# TRAFFIC IMPACT ASSESSMENT (TIA)

**Proposed Waste Management facility  
2-4 Hale Street, Botany**

Reference: 23.464r01v13  
Date: March 2025

This revised TIA has been prepared to accompany an amended SSD application to address comments concerning the proposal from Department of Planning, Housing and Infrastructure (DPHI) as contained in a letter dated 13 September 2024 (DPHI Reference: SSD-62855708), and Bayside Council as contained in a letter dated 9 September 2024 (Council Reference: SSD-2024/10).

1 TRUCK DRIVEWAY SECTION
1 : 100

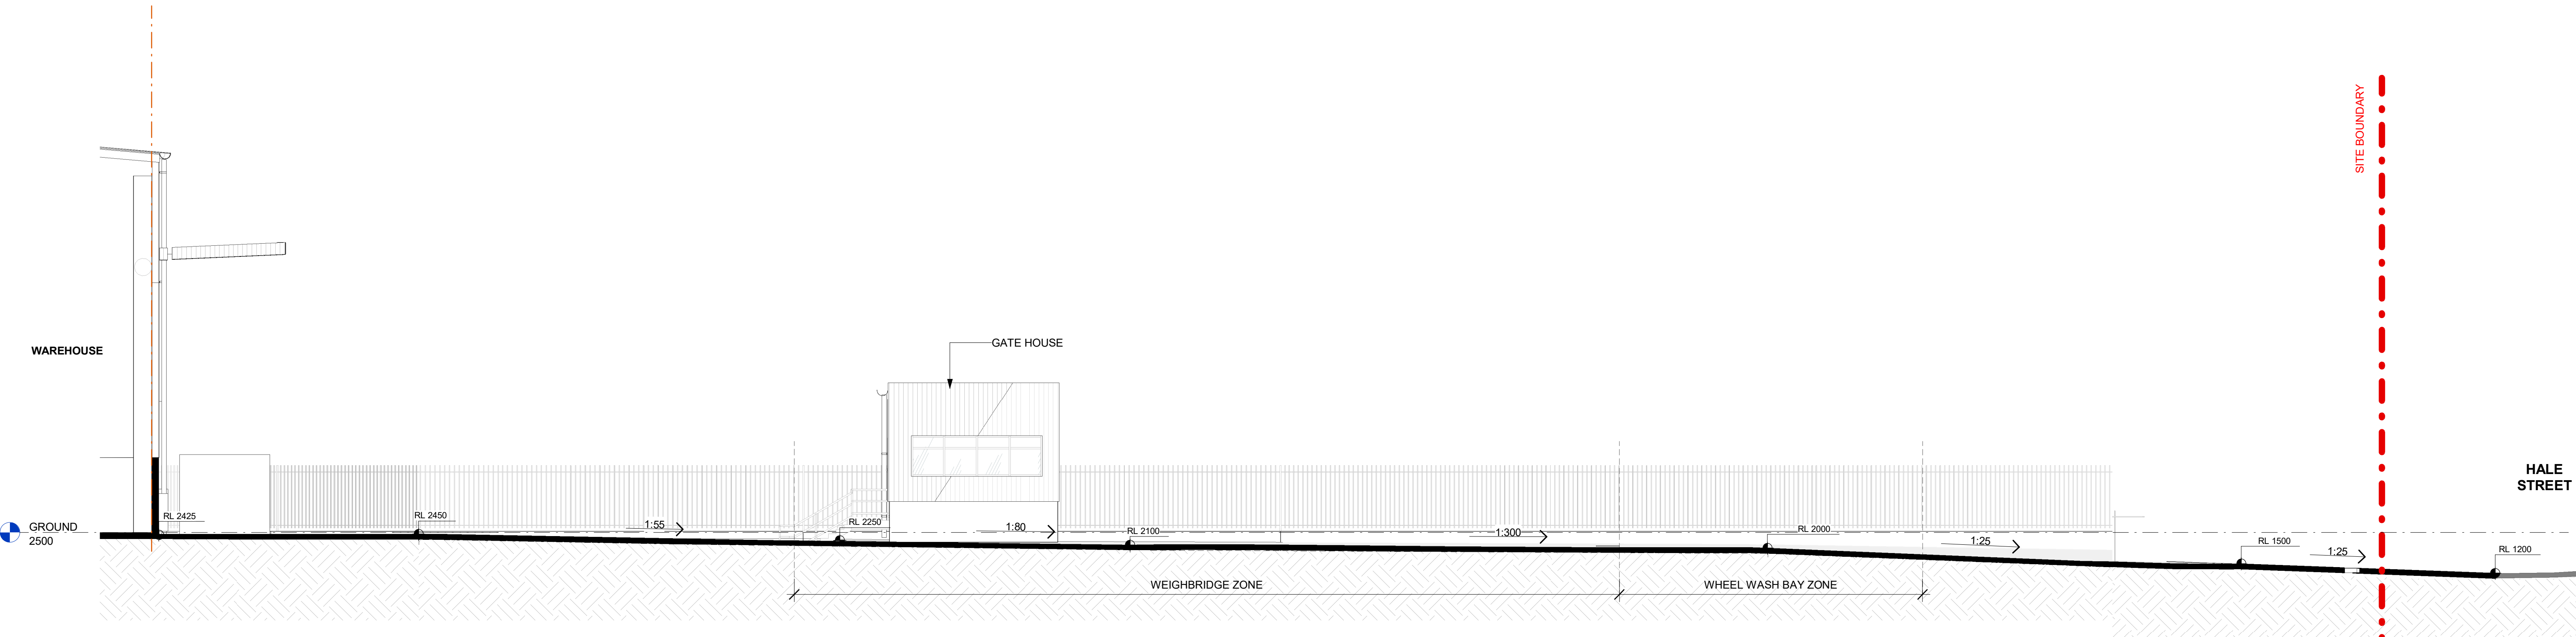
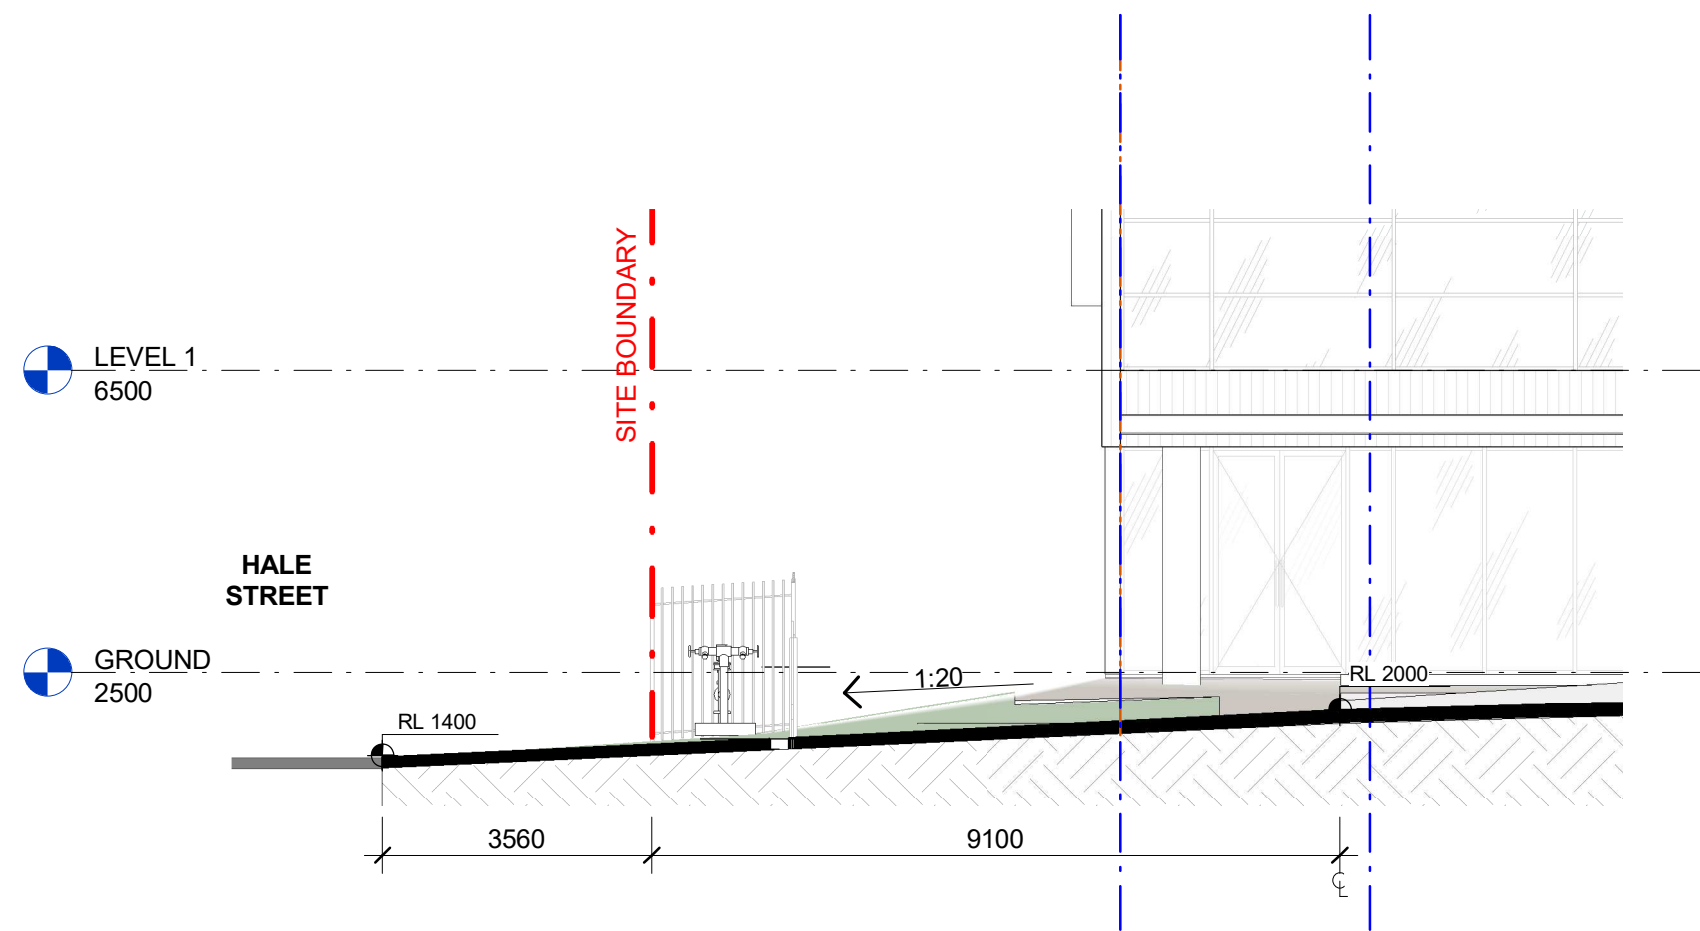
<p>A longitudinal driveway profile is to be submitted for each driveway. The profiles shall start in the centre of the road and be along the critical edge (worst case) of the driveway. Gradients and transitions shall be in accordance with AS2890.1:2004 &amp; AS2890.2:2018. The profile shall include all relevant levels, grades (%), headroom clearances and lengths. The existing boundary levels shall be clearly shown on the profile. Any change to the existing boundary levels requires approval from Bayside Council.</p>	<ul style="list-style-type: none"> <li>A longitudinal driveway profile has been prepared demonstrating compliance with AS 2890.1 (2004) and AS 2890.2 (2018) and has been submitted as part of the updated SSD package.</li> </ul>
<p>Internal driveway gradients shall be clearly shown on the plans complying with AS2890.1:2004 and AS2890.2:2018.</p>	<ul style="list-style-type: none"> <li>Internal gradients have been clearly shown on the plans demonstrating compliance with AS 2890.1 (2004) and AS 2890.2 (2018) and has been submitted as part of the updated SSD package.</li> </ul>
